Application no: H16-0514-10

Description: Installation of satellite dish

Location: 19 Hall Place
Spalding
Lincs
PE11 1SQ

Amendment: Amendment to existing/proposed elevations
(Dwg. no. 1385/10/1C)

Title	Proposed Satellite Dish
Site	19 Hall Place Spalding, Lincs
Date	June 2010
Scale	1:100 @ A3
Dwg No.	1385 / 10 / 1
 01234 360453 01234 312453 e: frank@aragonland.co.uk web: www.aragonland.co.uk LAND AND PLANNING UK LLP

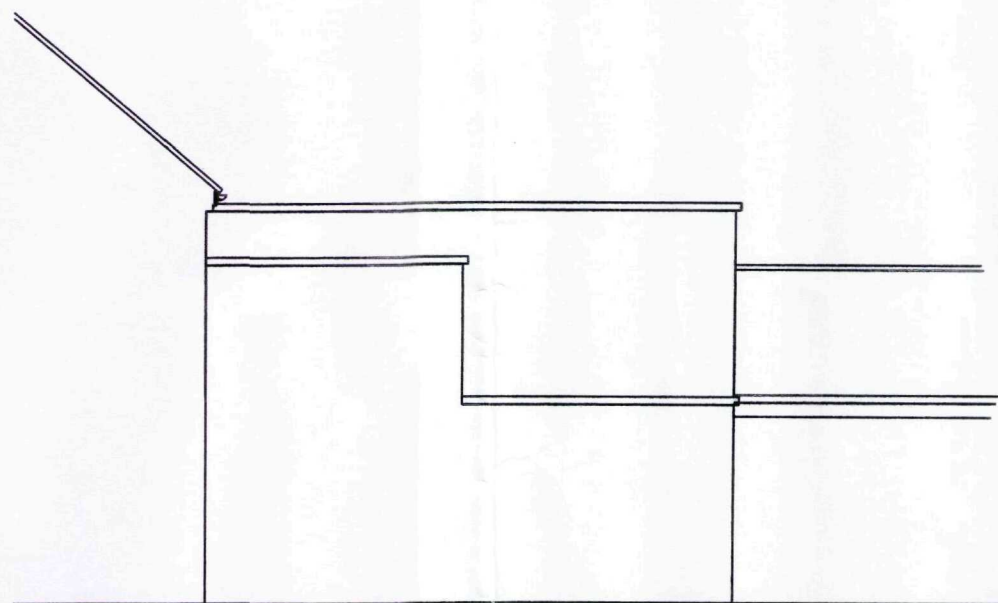
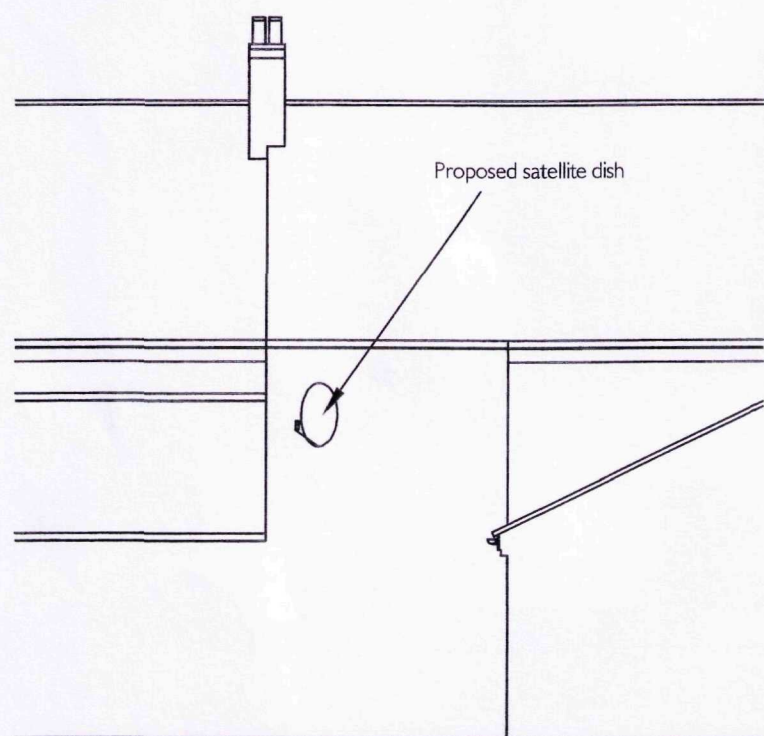
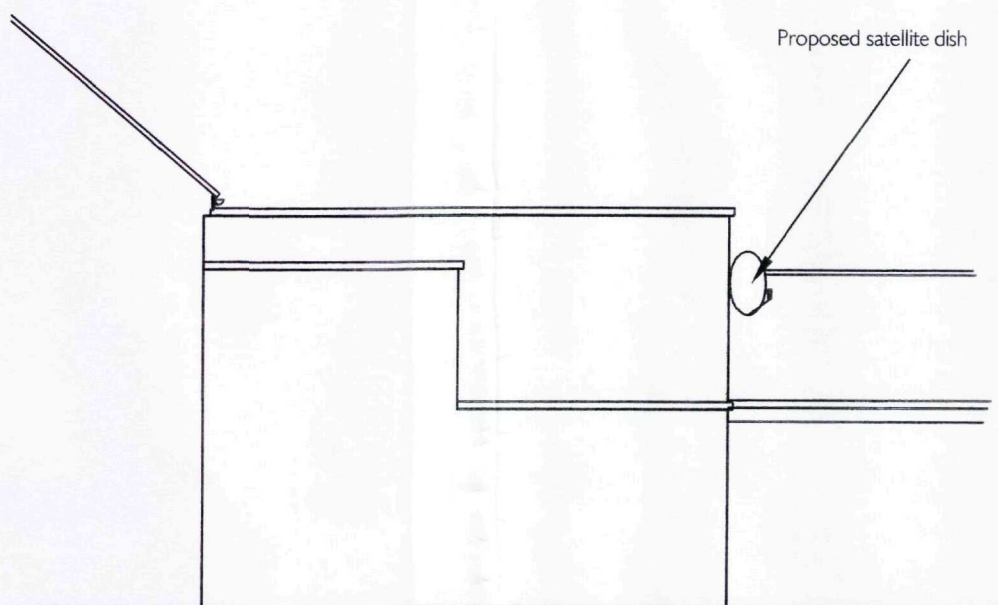
'For certainty's sake I would be grateful if you could supply an amended side elevation drawing picking up those outbuildings at the rear of the site backing on to Chapel Lane. This should then clarify the position of the proposed dish in relation to those previously approved, as well as helping the Council assess whether there will be any visual impact in views from outside the site.

In short, your side elevation drawing should include the buildings at the rear of the site backing onto Chapel Lane. It should also indicate the position of the other dish and antenna previously approved."

Your most recent email and further amended drawing was received yesterday, a fortnight after I had provided you with this information, and nearly 6 weeks since I first raised this issue. Your drawing is inaccurate and does not indicate the position of the previously approved dish and antenna as requested. You seem surprised that I have not previously suggested that the proposed dish should be repositioned. However, as I was not certain precisely where the dish was proposed it was impossible for me to make any such suggestion.

Unfortunately this drawing clarifies nothing- it does not appear to have been prepared on the basis of a physical survey. In light of the amount of time that this has taken and the failure to provide accurate information I intend to move both files through with a recommendation for refusal on grounds of insufficient information to enable the Local Planning Authority to fully assess the proposal. You may be disappointed that this outcome has been reached late in the day, but had accurate survey and proposal drawings been submitted from the outset these issues could have been raised and dealt with much sooner.
